Subject: RE: Archaeological Brief and Specification Application Form Land at the Leys and Ivy Farm Yaxley

please find attached the draft WSI for the trench evaluation at Leys Lane, Yaxley. Please could you approve or let me know of any necessary amendments.

Figure 2: Trench locations superimposed on the geophysical survey

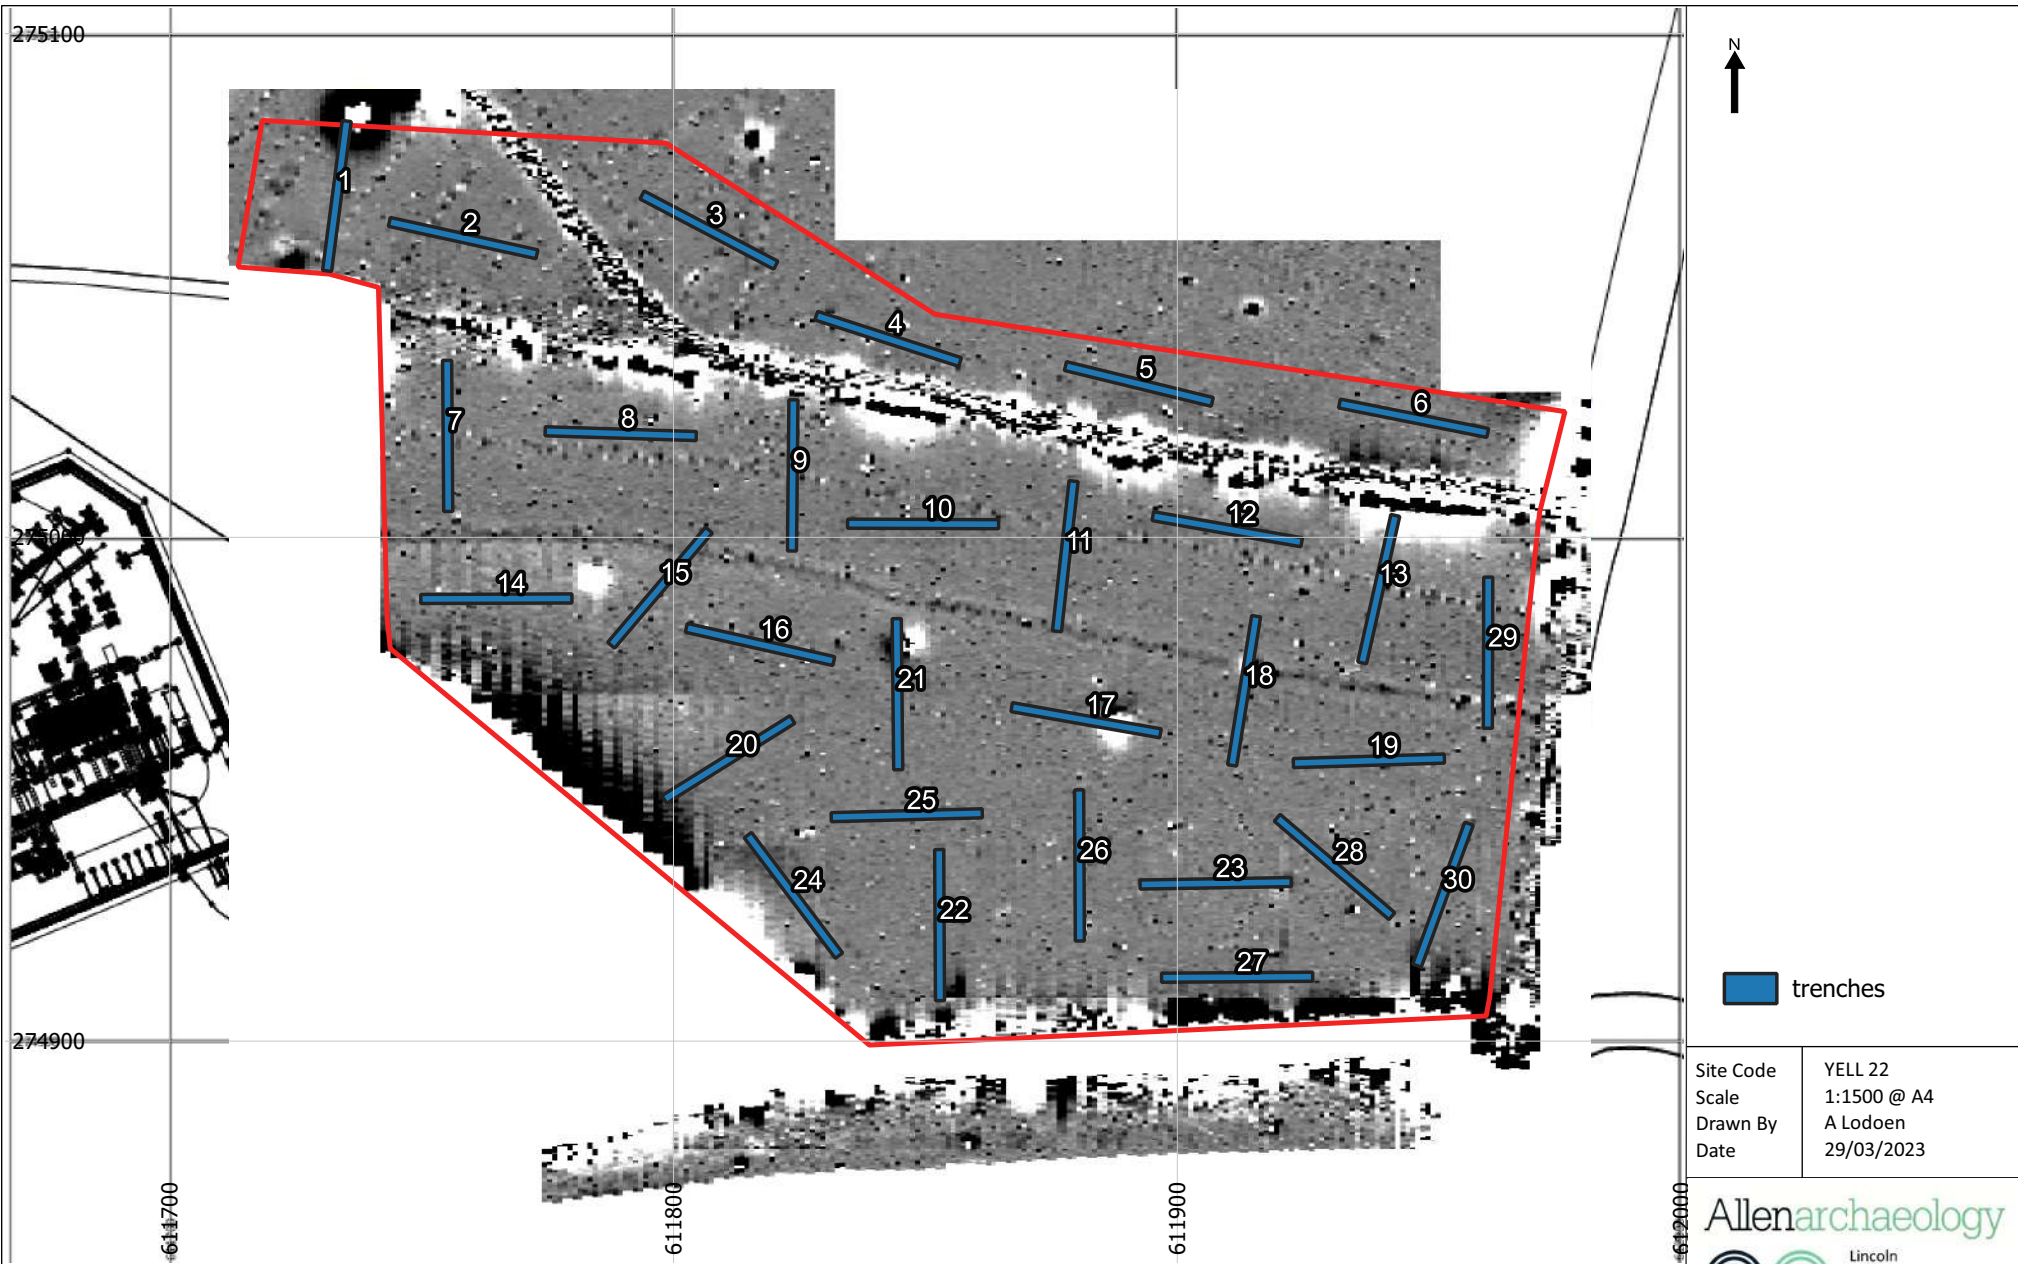
We've just heard from the client that they would like to move four of the trenches, 3, 4, 5 and 6, the ones above Leys Road, onto the main area. This is partly because they won't actually be building or altering anything in this area, and it's outside their agreed option with the landowner (despite it being within the site area shown on their locations plan).

Hi Robert,  
Please can tr 17 be moved and utilised as per my previous trench plan, and a couple of others just need tweaking slightly to catch anomalies on the geophysics and fill in a few gaps.  
Best wishes,  
Rachael

- With regards to the trench plan, we would ask for more of a systematic grid array please rather than the current box arrangement to avoid gaps. A roughly N-S/E-W orientation more in line with the field orientation would be preferable where possible. Linear features should not be tested at oblique angle. Please can you also include a copy of the trench plan over the geophysics greyscale

Figure 2: Trench locations superimposed on the geophysical survey

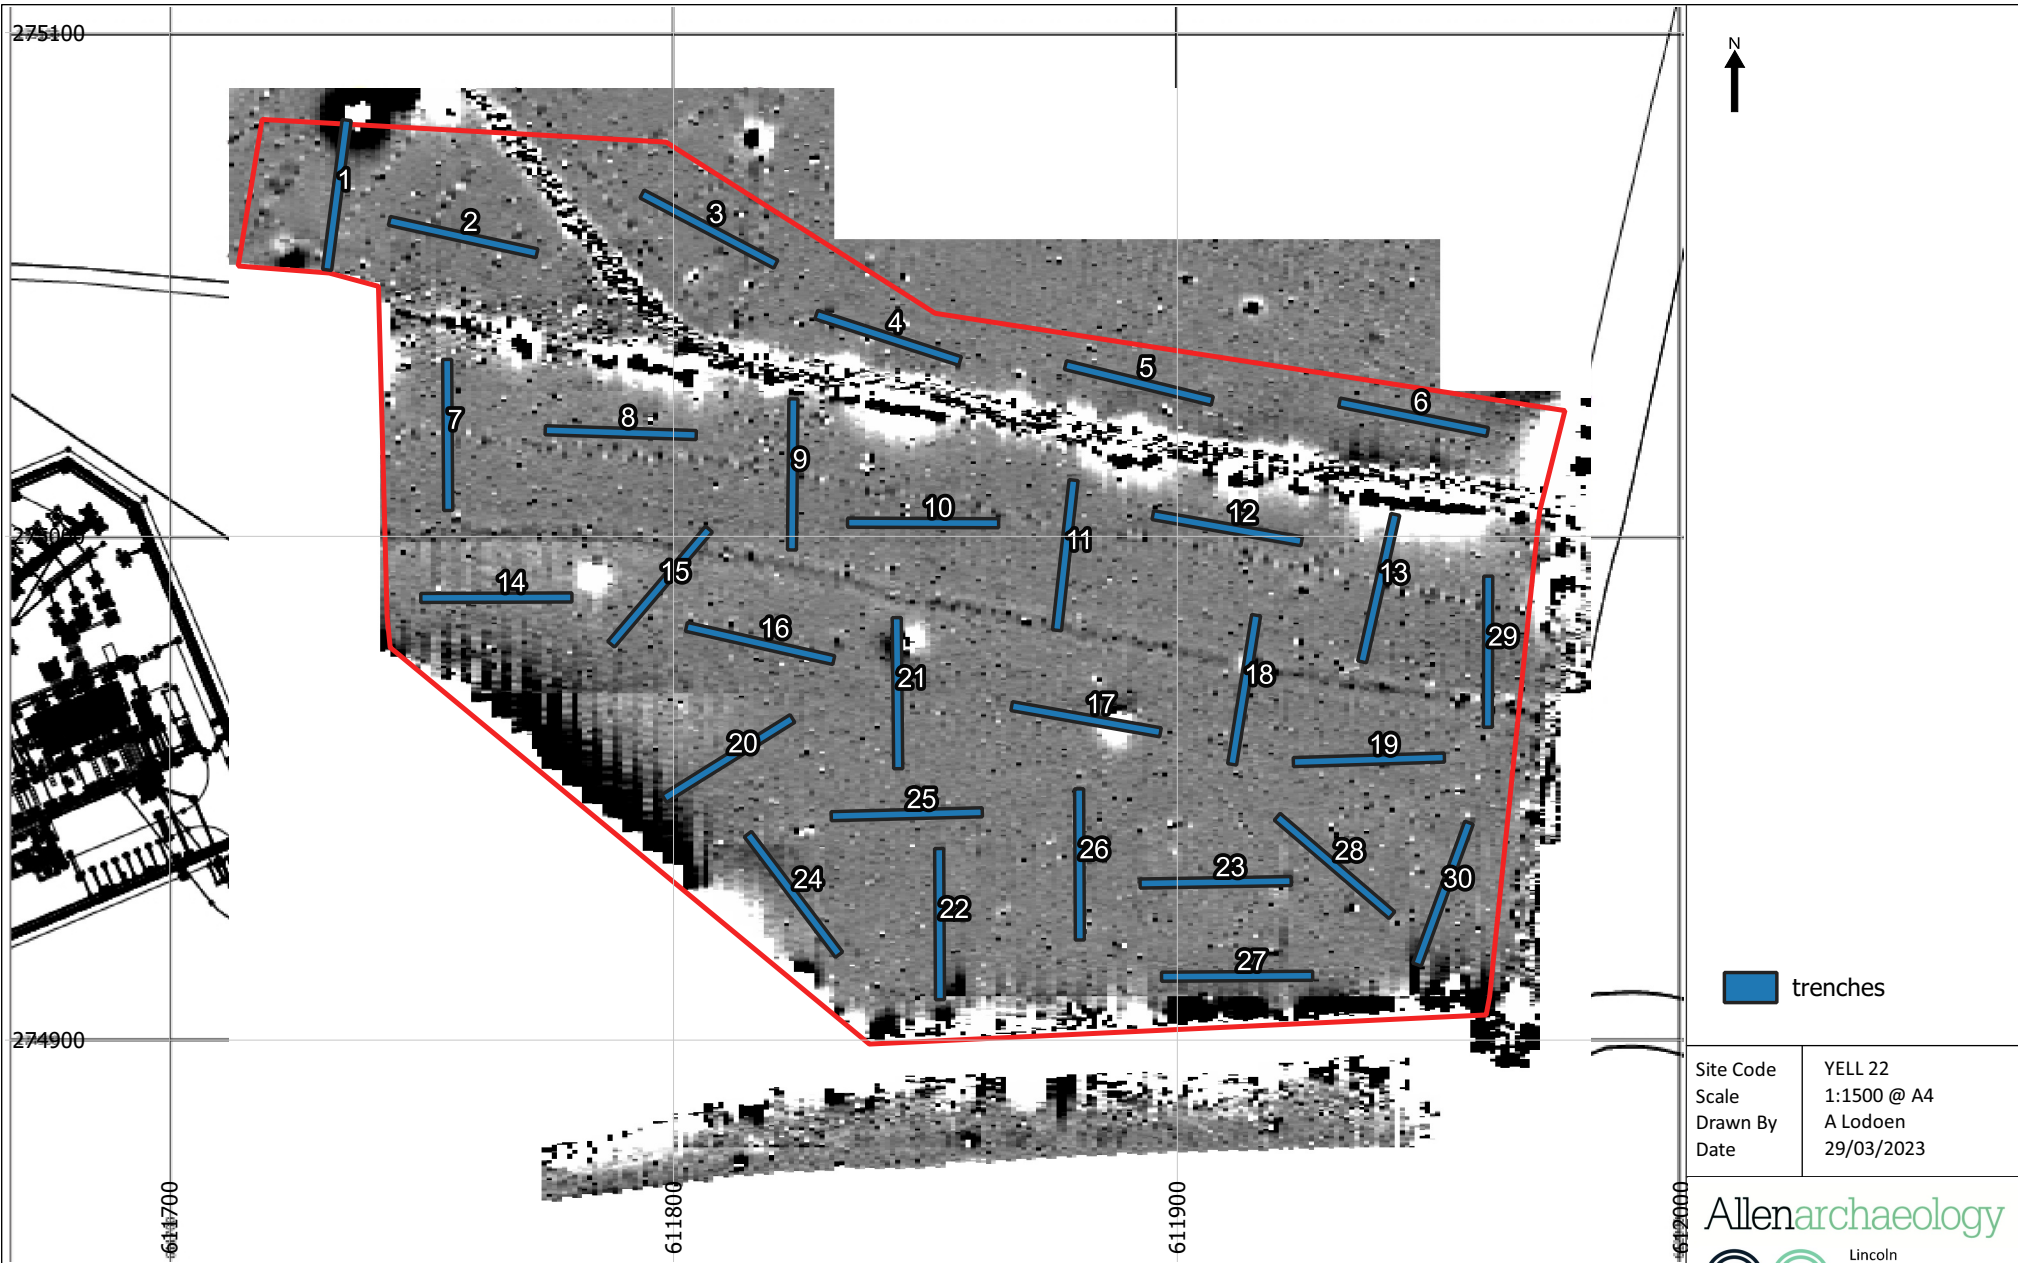
The text is now fine, but with regards to the trench plan, I meant something more along the lines of this please:
